CSV ARCHITECTS

Re: Site Plan Control Application
File Number: D07-12-22-0094– 78 Rosemount Avenue

In response to your comments dated August 11th, 2022, I am providing the following information:

SITE PLAN

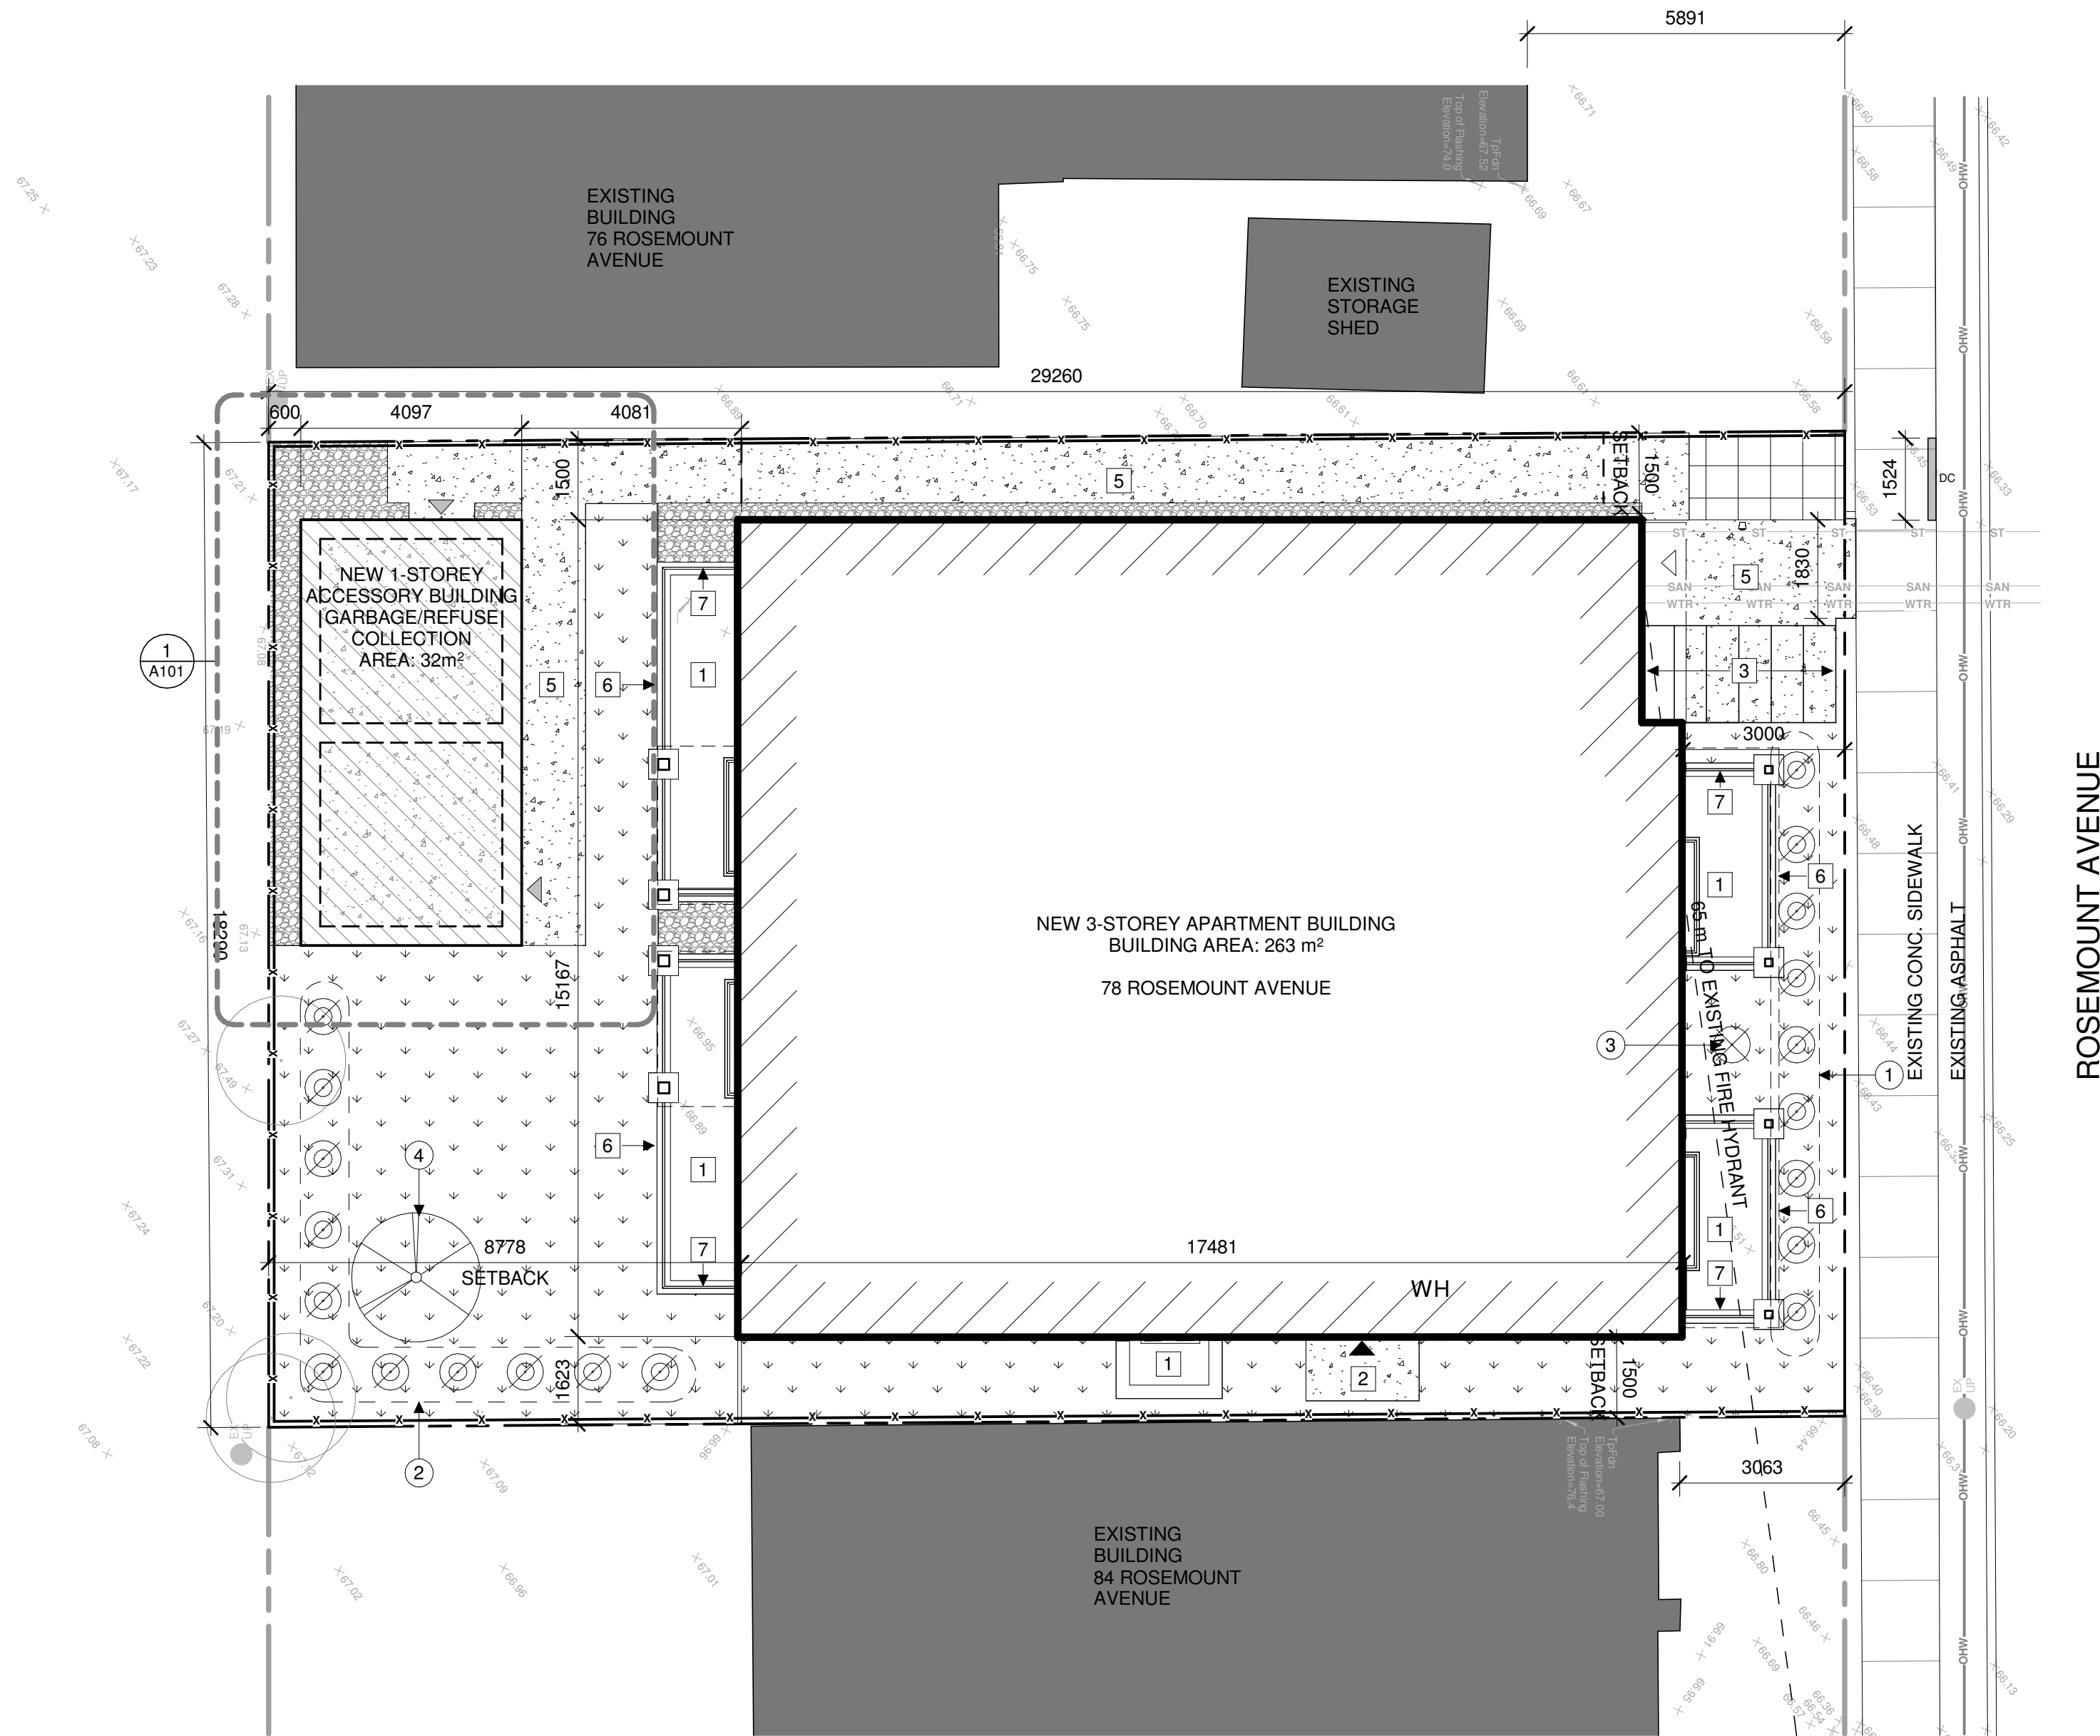
5. Noted. Please see attached A100.

42. The reference survey is included on A100.

ACCESSORY BUILDING DETAILS

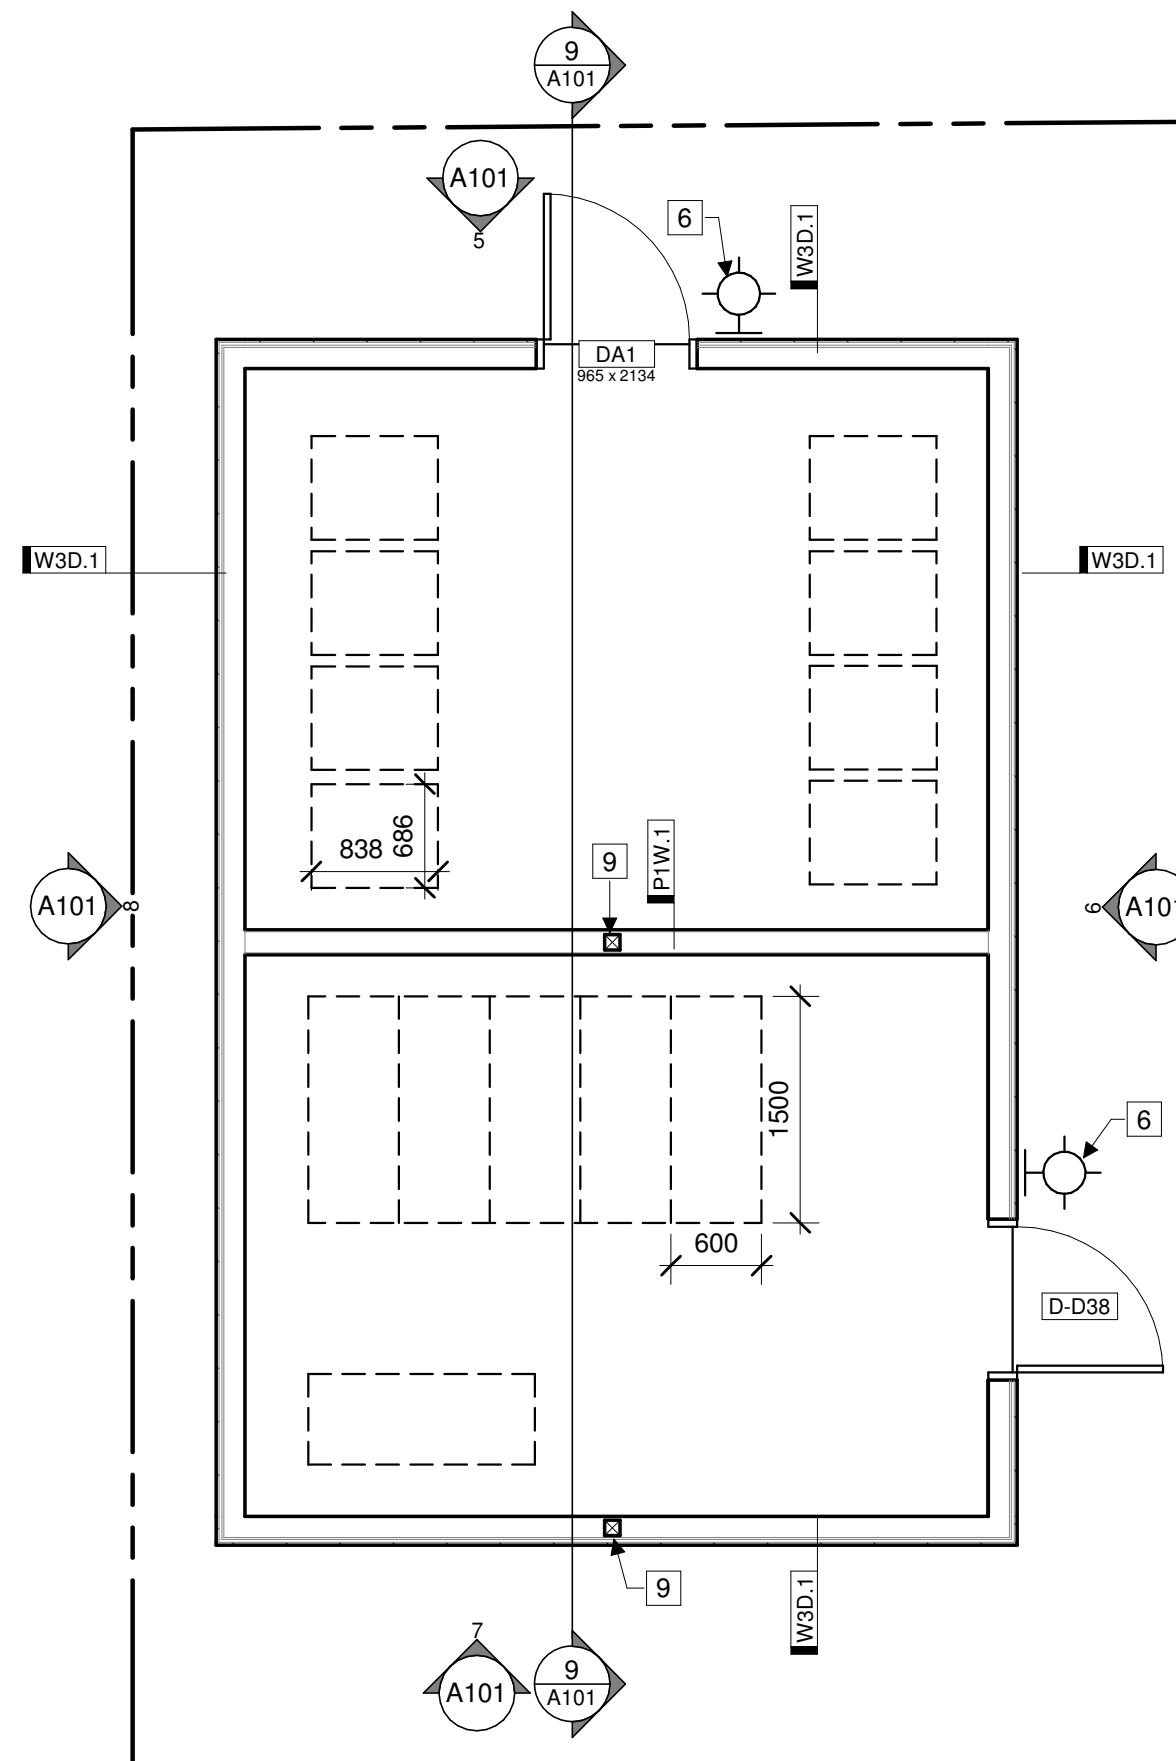
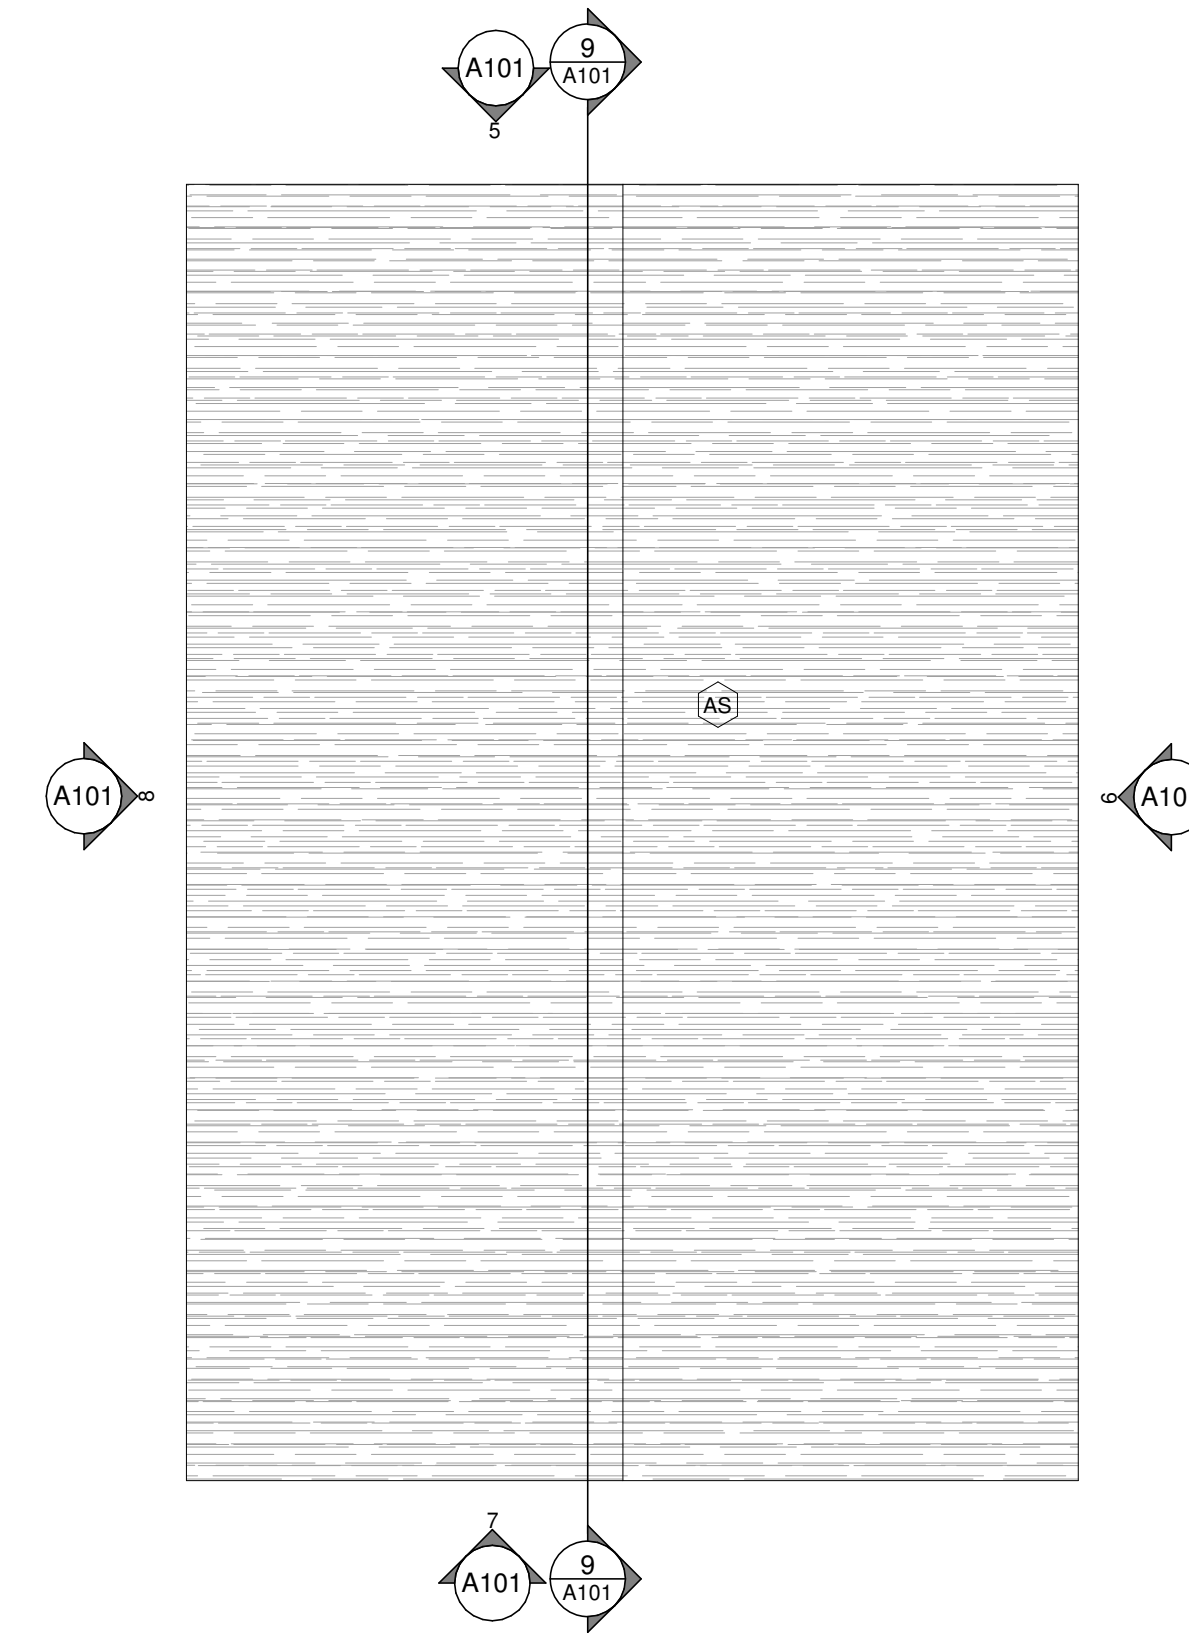
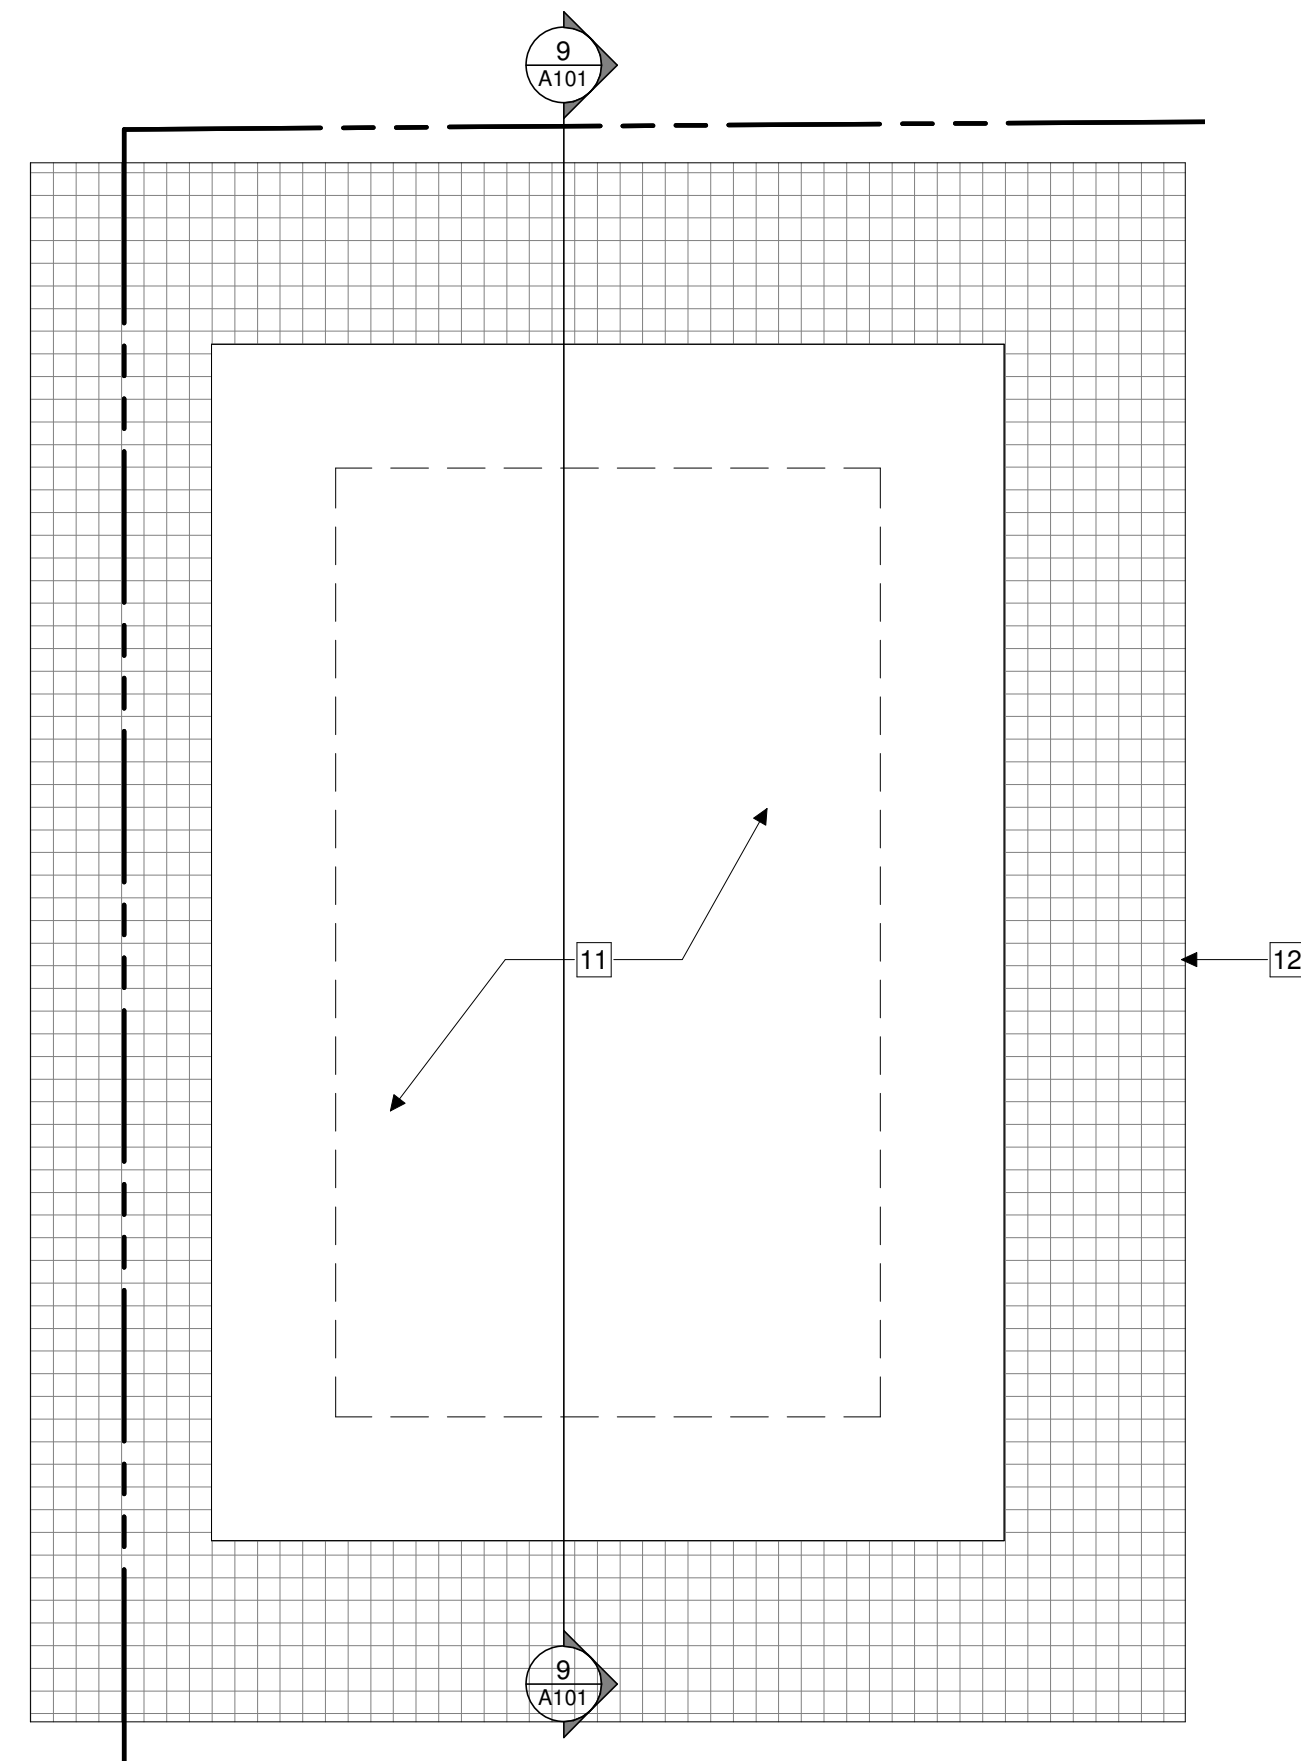
44. Noted, a set of double doors has been indicated on revised drawing A101.

45. Noted, (assuming there was a typo and this is meant to indicate 1 organics bin, rather than 11). The allocated area for these bins is indicated in plan on drawing 2/A101.
